Recommendation Report for Works to Tree(s) on trees subject to a Tree Preservation Order (TPO)

REF NO: R/139/19/T

LOCATION: 8 Elm Farm Cottages
Old Manor Road
Rustington
BN16 3FD

PROPOSAL: Fell 1 No. Douglas Fir tree.

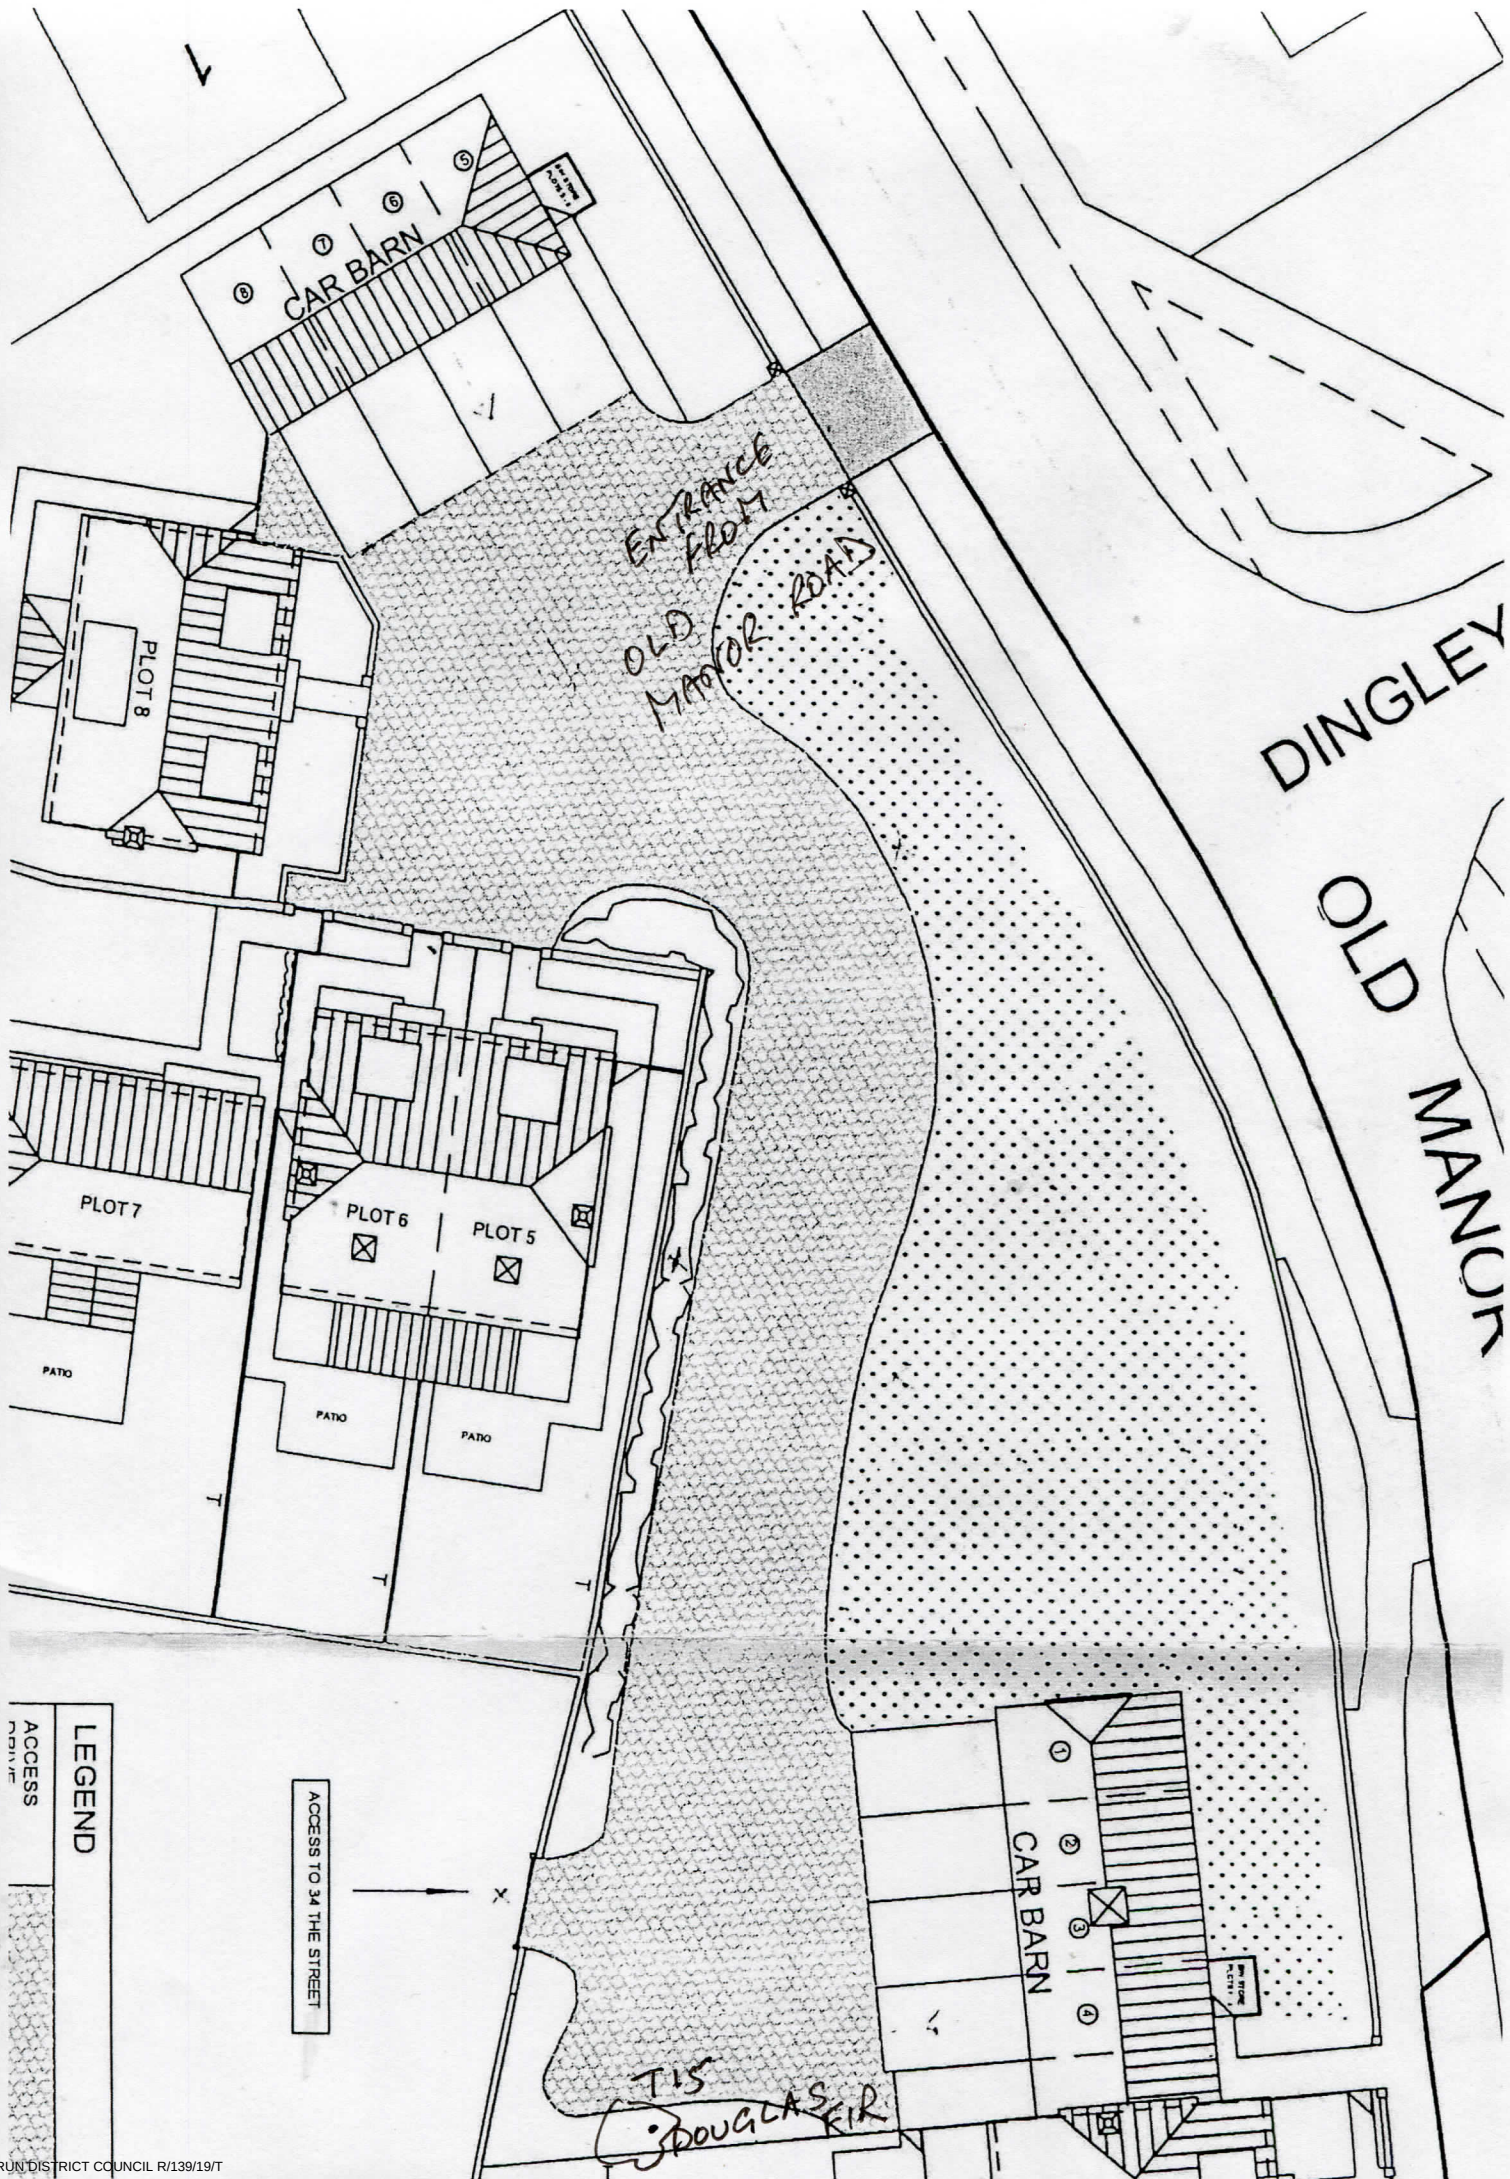
There is no Douglas fir at the location marked on the applicant's plan drawing. That said, the sole forestry-type conifer which exists at that location is of near enough type and in isolation to leave no doubt that it is the subject tree.
